DELEGATED DETAILS DECISION

Report of the Head of Planning, Transportation and Regeneration

Address THE OLD VINYL FACTORY BLYTH ROAD HAYES

LBH Ref Nos: 59872/APP/2021/4268

Title Proposed Ground Floor Plan			
Site The Assembly Buildings, Hayes			
Drg. WH199/21/P/25.01d			
Date Nov 2021		Rev -	
Drawn JM		Scale 1:200 @ A2

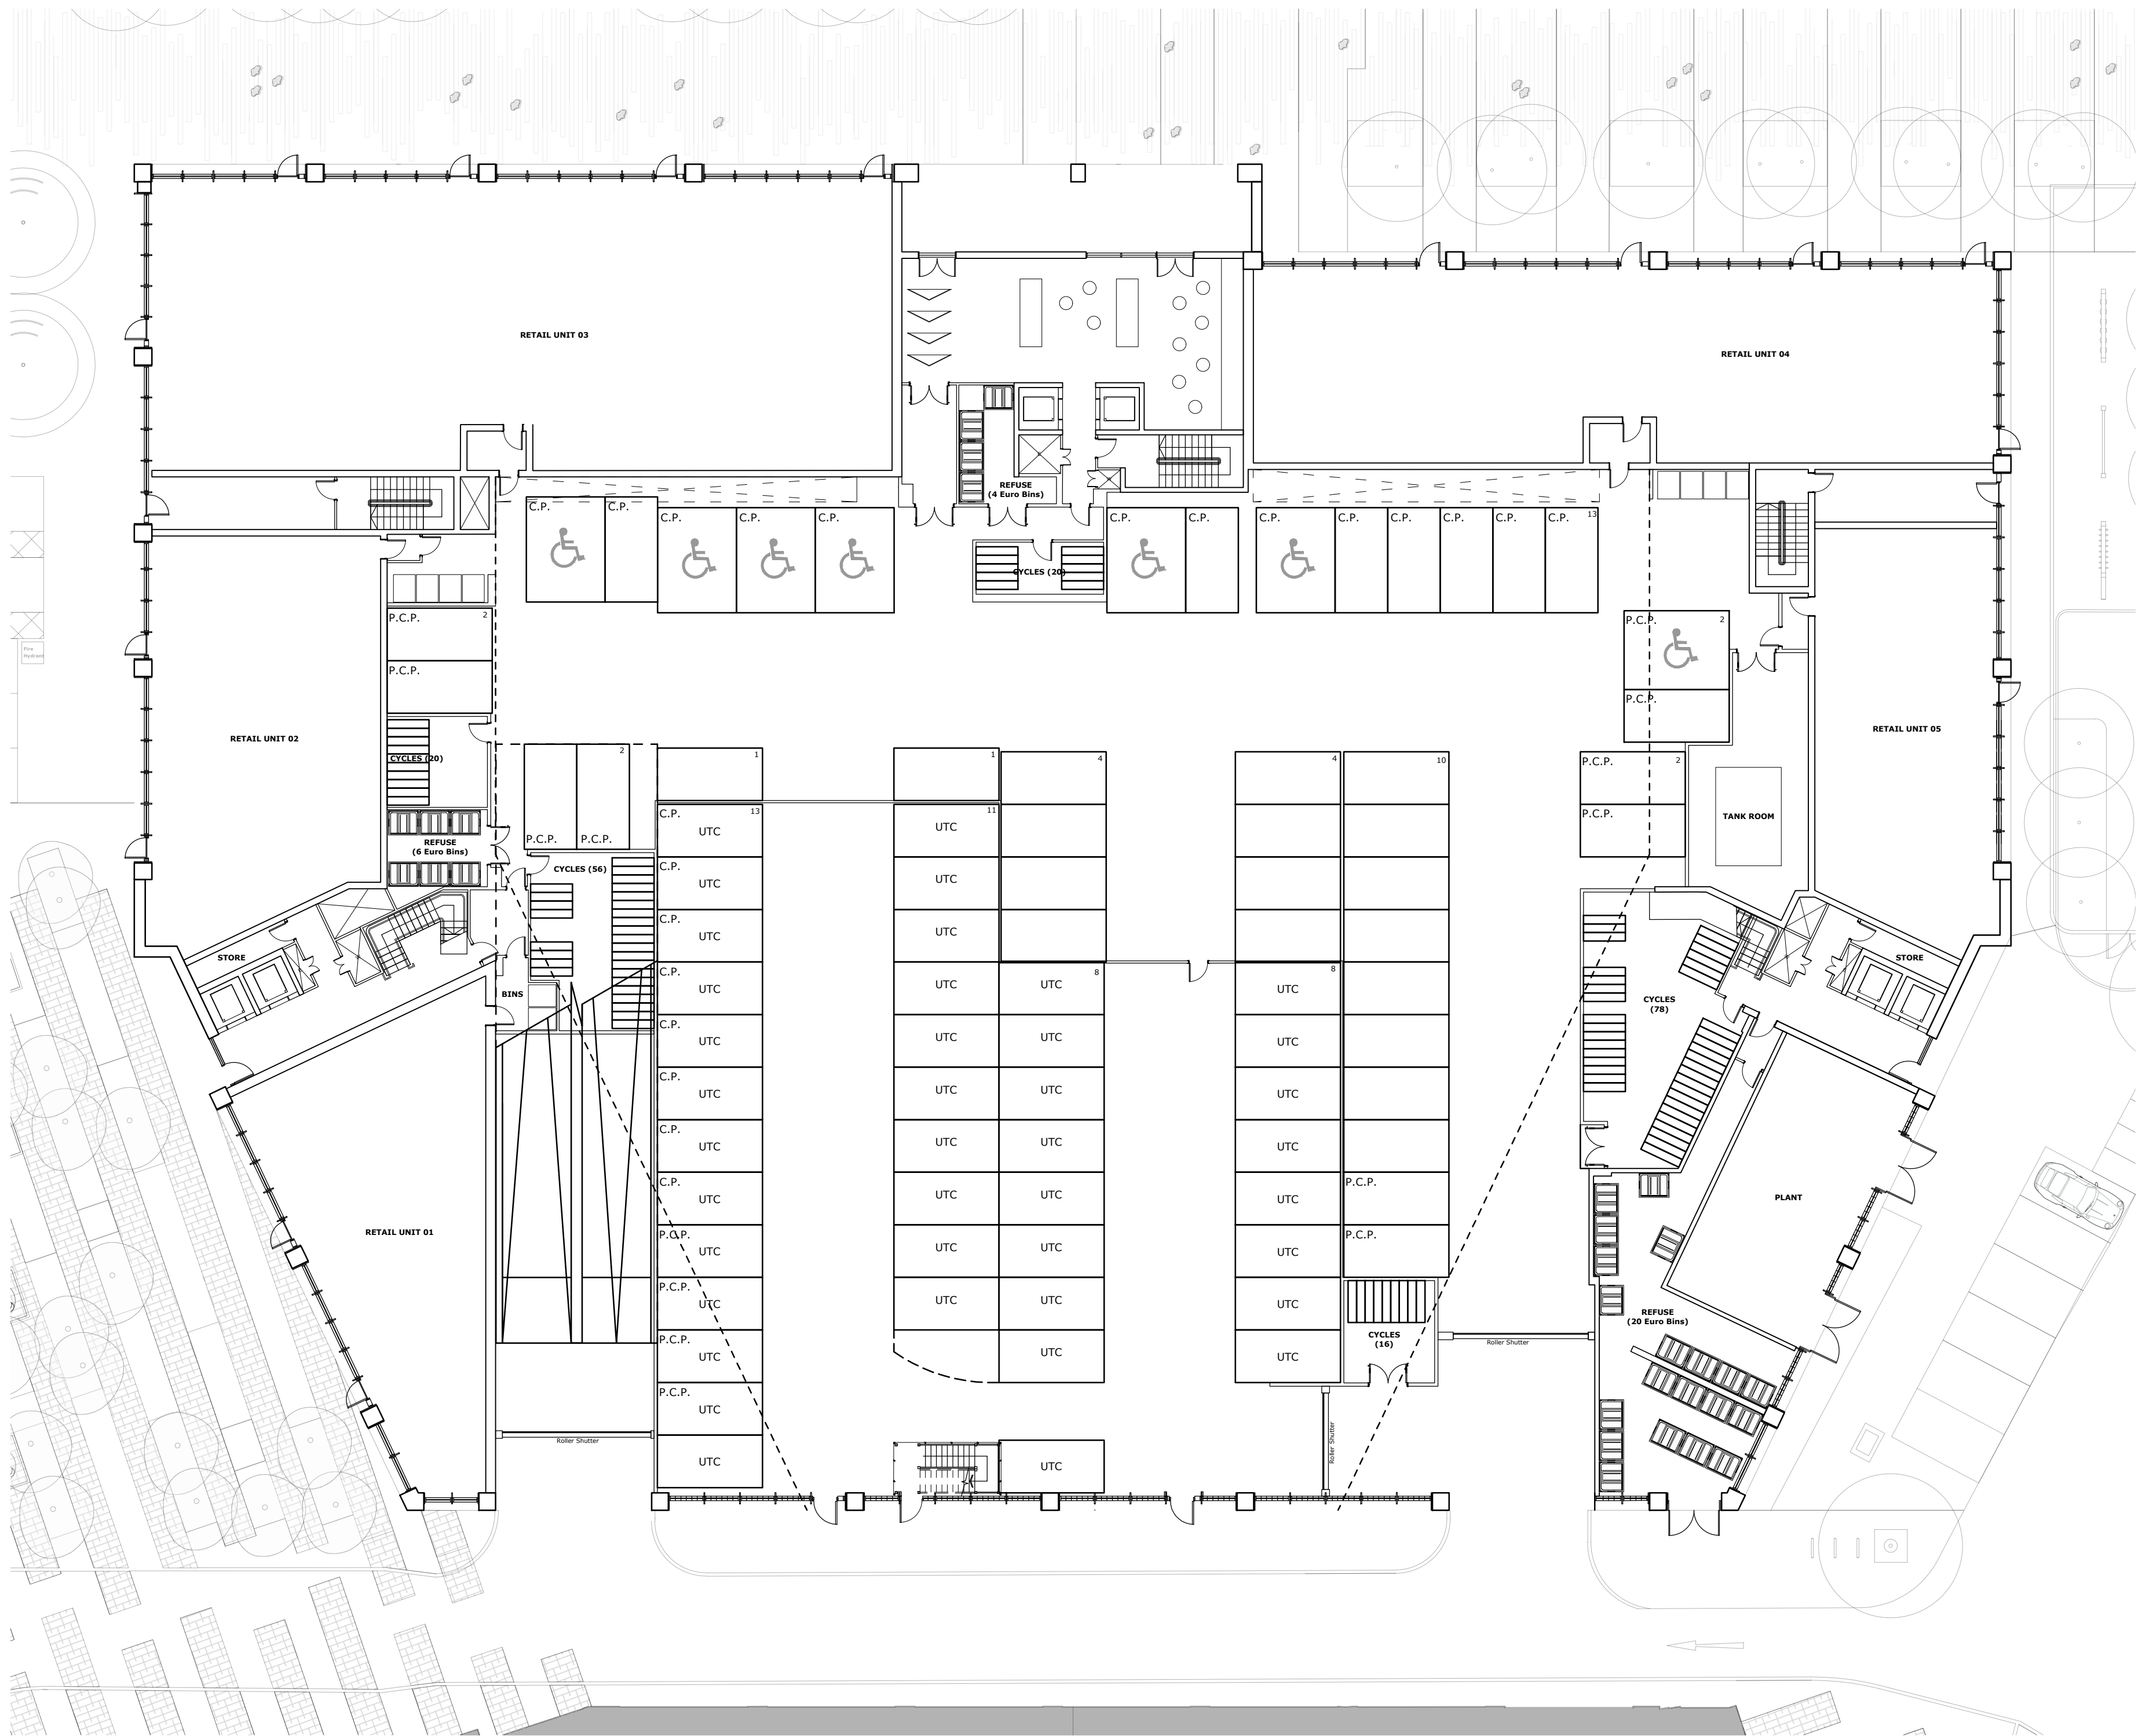
In addition to the above concerns the proposed location for the access stairs raises further concerns. At ground floor level the proposed staircase would block the tracking route provided by the applicant in the Section 2.5 of the Design and Access Statement (Rev B June 2020) submitted with the amended proposals (application reference 59872/APP/2020/342). As such it has not been demonstrated that the proposed staircase would not have a detrimental impact on vehicle movements and therefore parking and servicing availability for the development.

Title Proposed 1st Floor Plan	
Site The Assembly Buildings, Hayes	
Drg. WH199/21/P/25.02d	
Date Nov 2021	Rev -
Drawn JM	Scale 1:200 @ A2

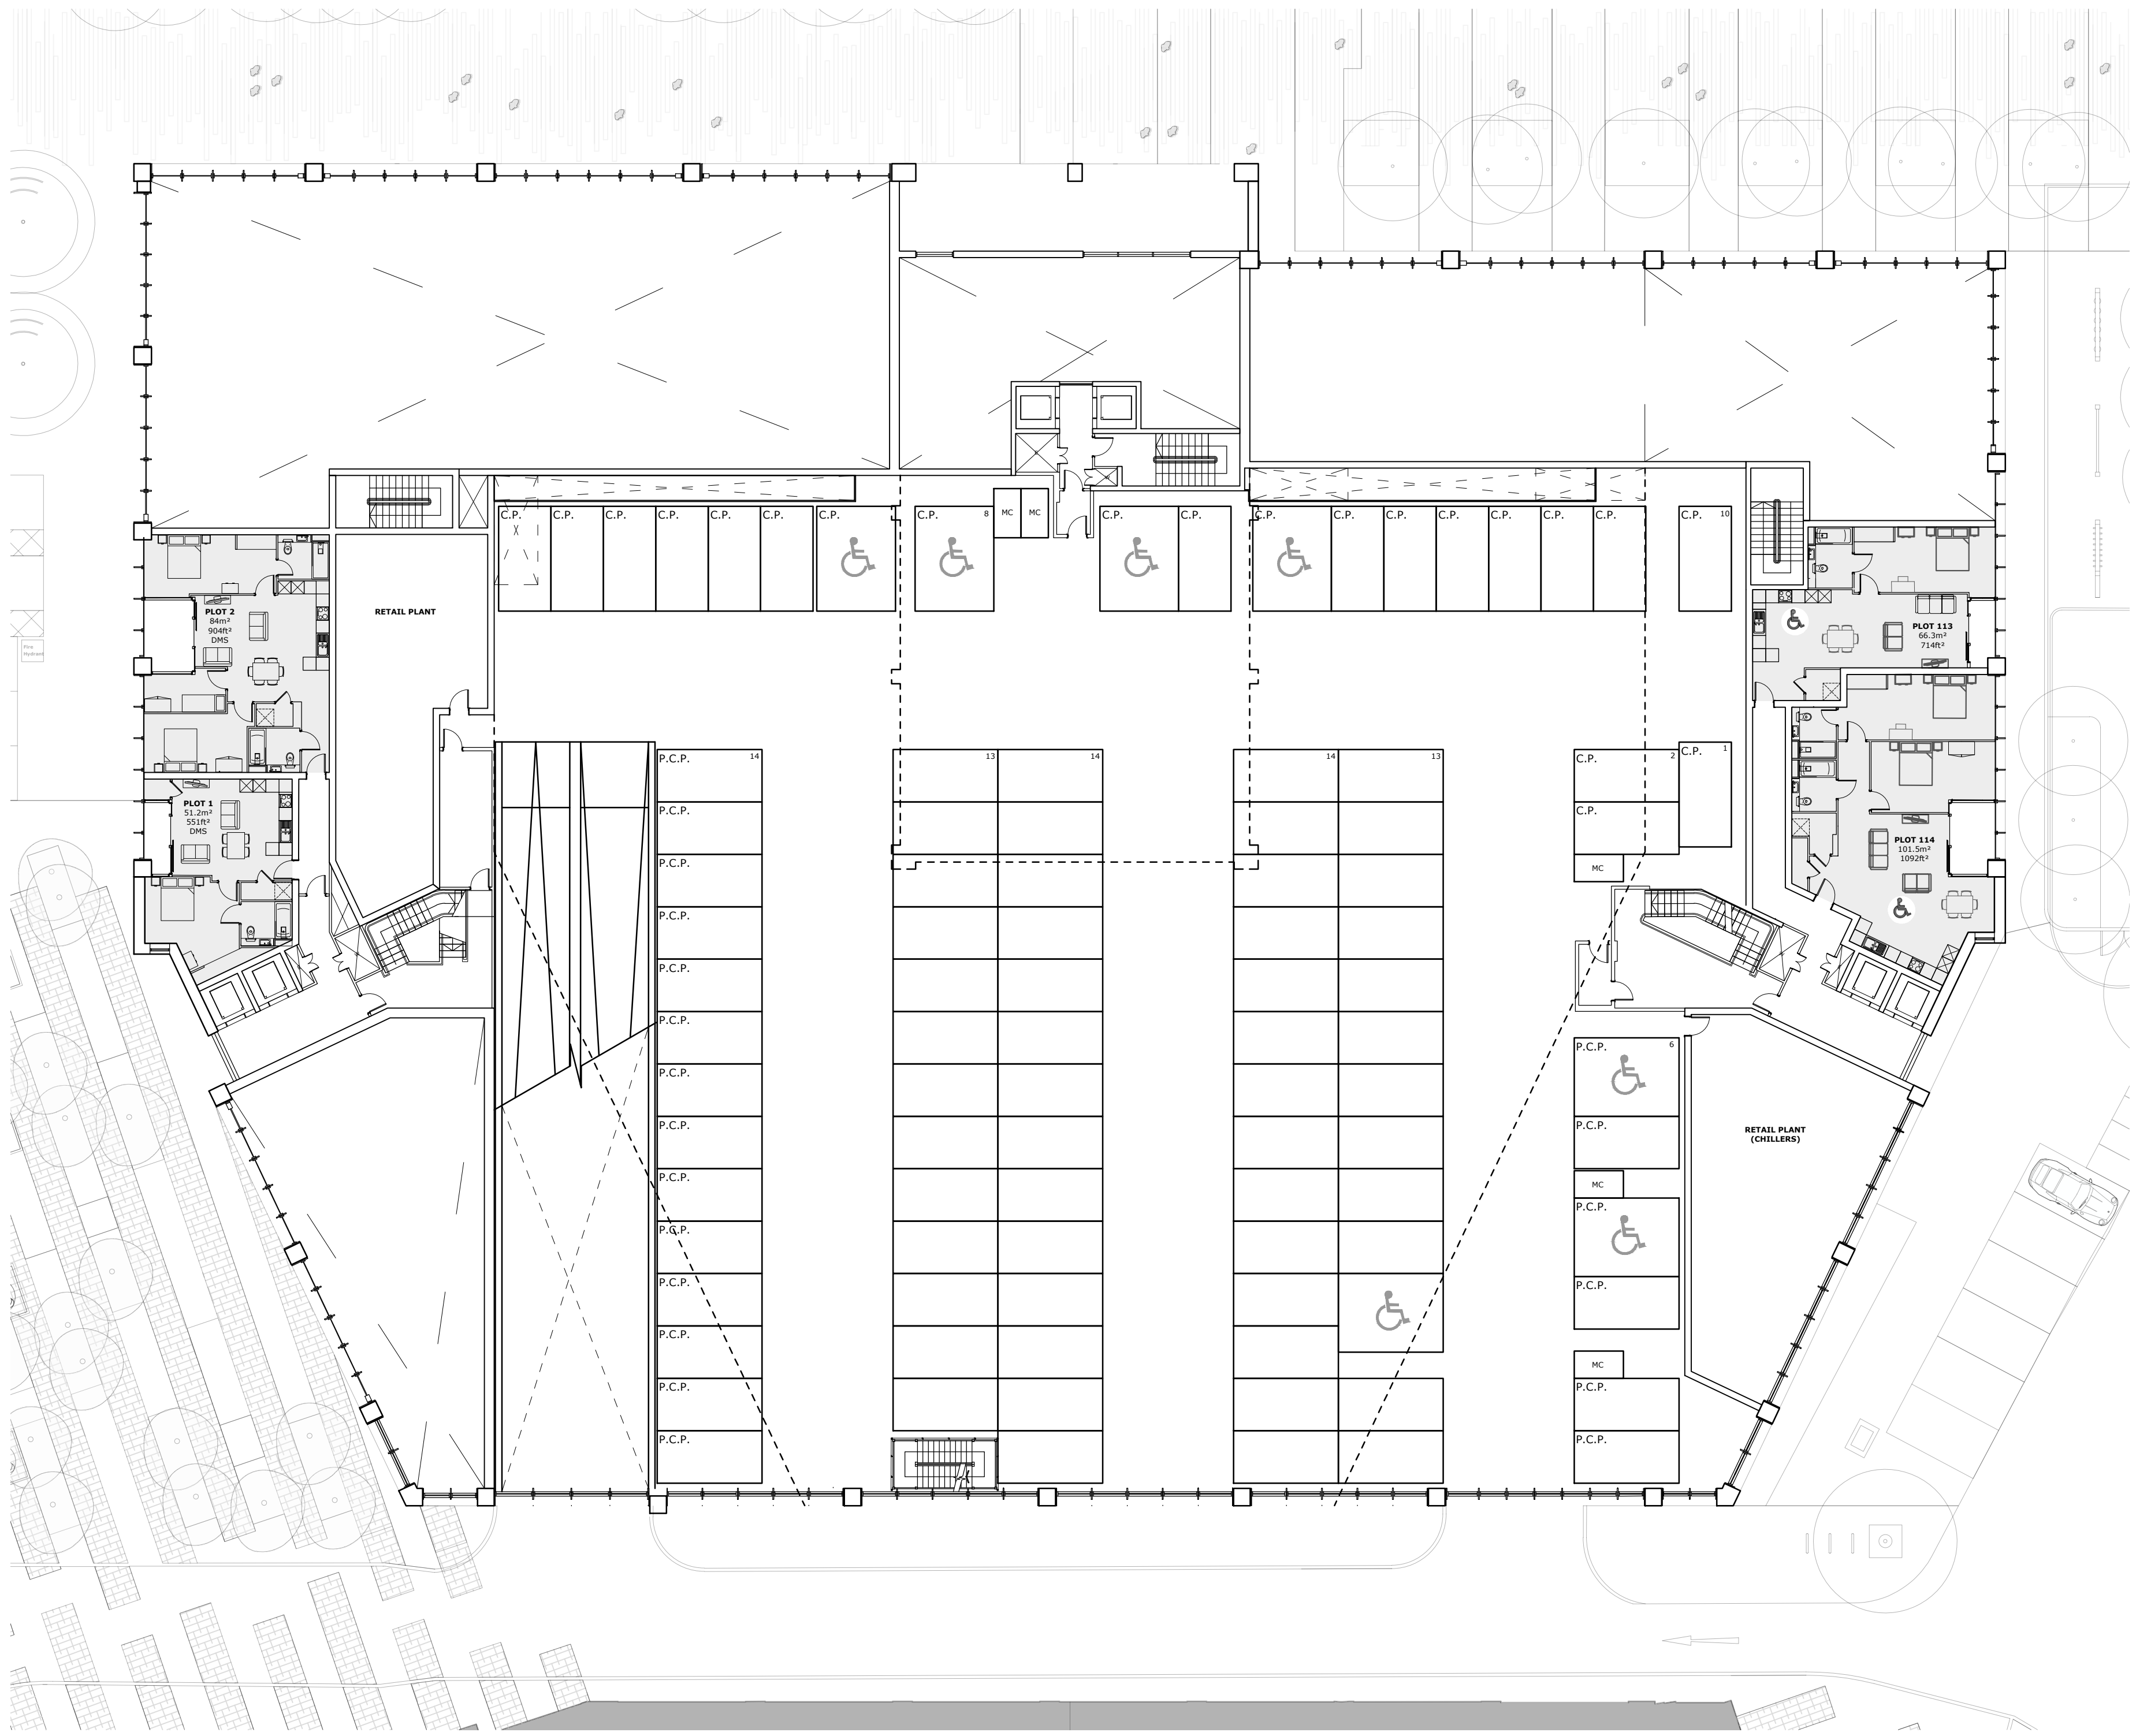
The proposed stairs would also result in a loss of parking as they are located where a parking space is approved at first floor level (as shown on approved drawing number WH199/20/P/25.02a Rev A). In addition the proposals would result in the loss of external amenity spaces on the podium (as shown on approved drawing number WH199/20/P/25.03a Rev A). The loss of parking and the loss of external amenity space are not considered to be acceptable.

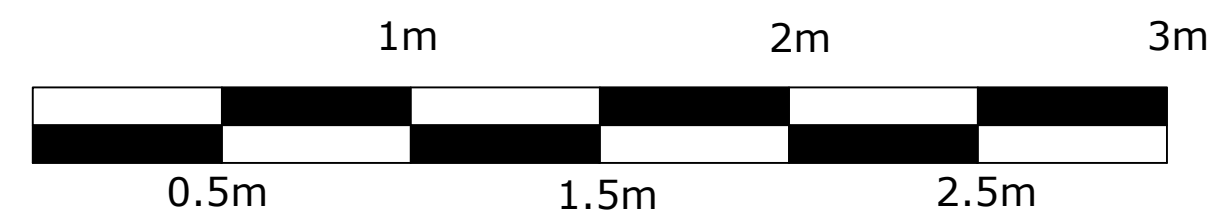
The submission only includes details of the proposed 'secure, lockable staircase'. There are no details provided which 'demonstrates the access proposals, hours of access and management procedures for access to the proposed podium by non-residents of the Assembly Buildings' as required by the wording of the condition. The submission only states that access would be controlled by the development management company.

Concerns are also raised by the location of the proposed public access point for the podium at the rear/back of house area of the building, rather than on one of the three principal elevations. The originally approved scheme provided the public access route to the podium at the main entrance to the building, making it a far more appealing route to the podium and therefore one more likely to be utilised. This access route via the main entrance is maintained in the amended proposals as shown on drawing numbers WH199/20/P/25.01a Rev A, WH199/20/P/25.02a Rev A and WH199/20/P/25.03a Rev A. There is a significant shortage of public open space within the locality of the site and the podium area provides an important contribution. The proposed location for the public access to the rear of the building is deemed to make the route undesirable and further from the main pedestrian route through the site, and as such is unacceptable. In addition a lift is provided at the entrance to the building. The Council's Access officer has reviewed the proposals and notes that it is unclear how with only a staircase as proposed, wheelchair users and others requiring inclusive access could gain access to the podium during the permitted times of access by members of the public. The principle access into the podium should be via one of three principal facades of the building, not the car park/rear entrance.
